Our ref: RA/2024/147770/01-L01
Your ref: 2024/91476

Date: 10 December 2024

ERECTION OF 24 DWELLINGS – CLOUGH FARM, LONG LANE, EARLSHEATON, DEWSBURY, WF12 8LQ

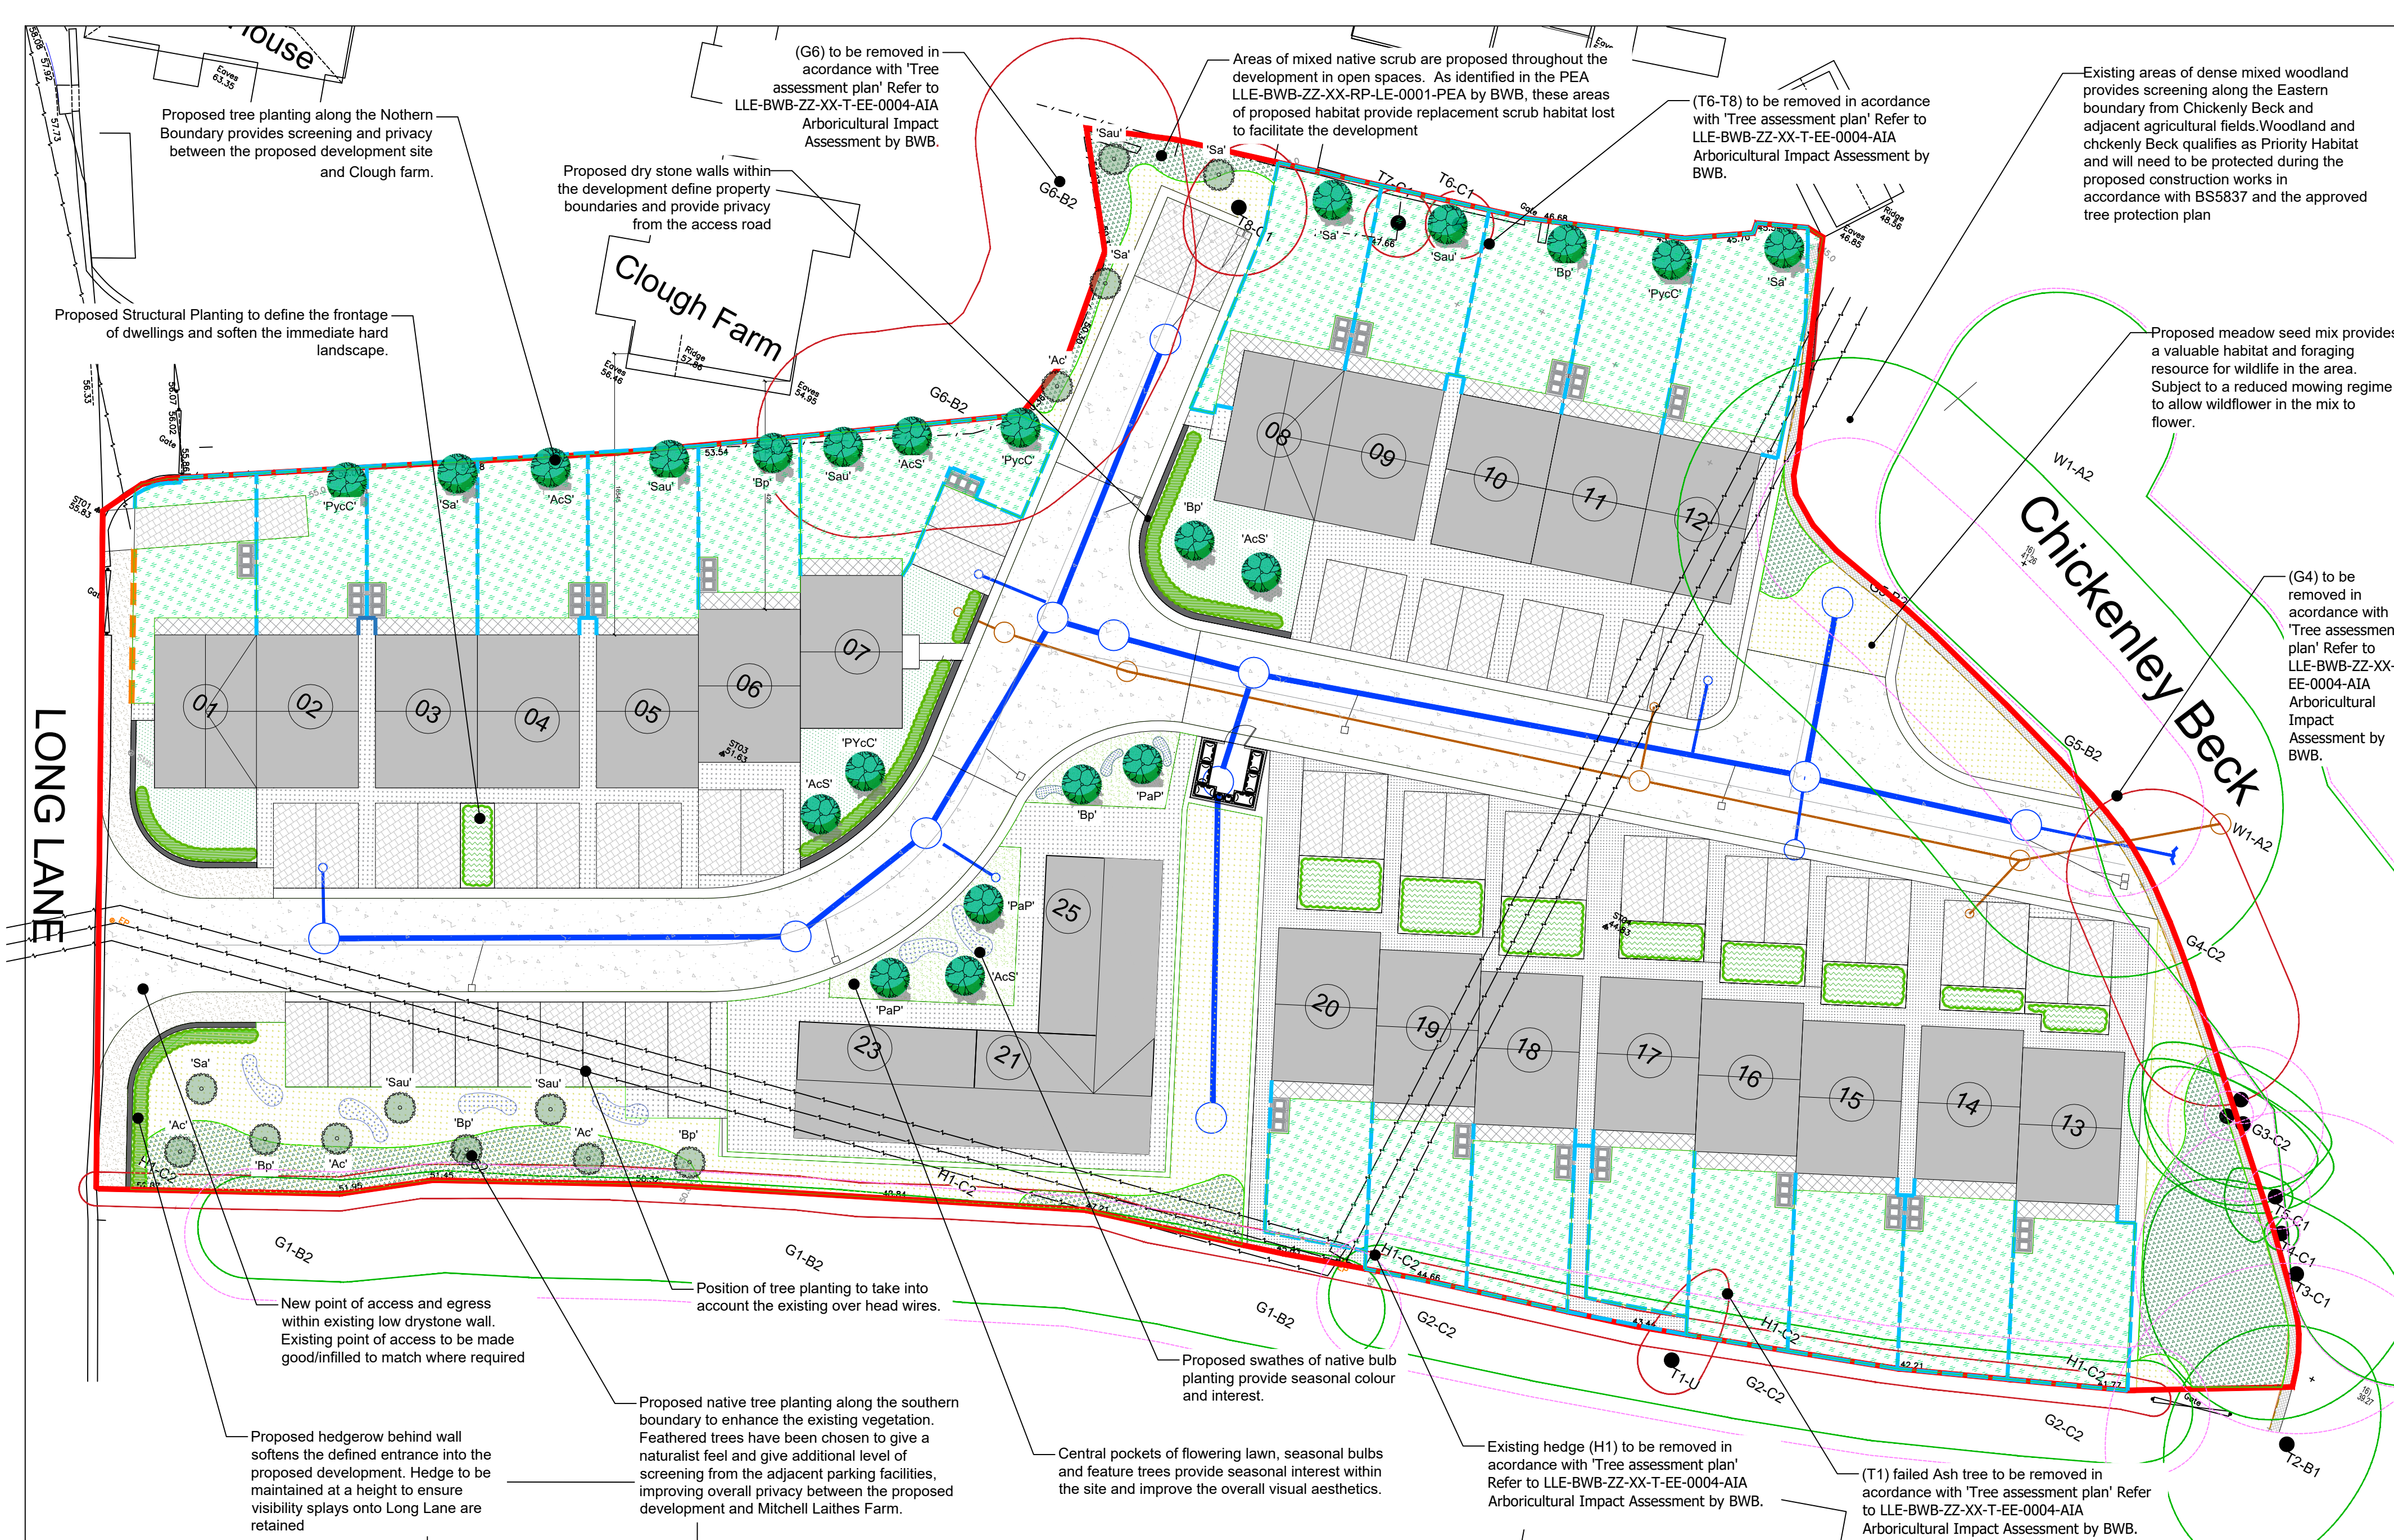
However, the proposed development red line boundary (as shown in drawings submitted) appears to fall within 10m of the bank top of Chickenley Beck watercourse.

We recommend that the LPA seeks clarity on the alignment and proximity of the proposed development's red line boundary to the watercourse habitat, including the riparian zone. Where the proposed development falls within 10m of the river bank top, we recommend that an updated BNG assessment that includes the watercourse module and demonstrates a minimum 10% net gain in Watercourse Units is submitted.

The proposed development will therefore be acceptable if a planning condition is included requiring a scheme to be agreed to protect a 10-metre-wide undeveloped buffer zone from the 'Calder from River Colne to River Chad (GB104027062631)' waterbody, which includes Chickenley Beck.

No development shall take place until a scheme for the provision and management of a 10-metre-wide buffer zone alongside the Chickenley Beck ('Calder from River Colne to River Chad (GB104027062631)') waterbody has been submitted to, and approved in writing by, the local planning authority. Thereafter, the development shall be carried out in accordance with the approved scheme. Any subsequent variations shall be agreed in writing by the local planning authority, in which case the development shall be carried out in accordance with the amended scheme. The buffer zone scheme shall be free from built development including lighting, domestic gardens, and formal landscaping.
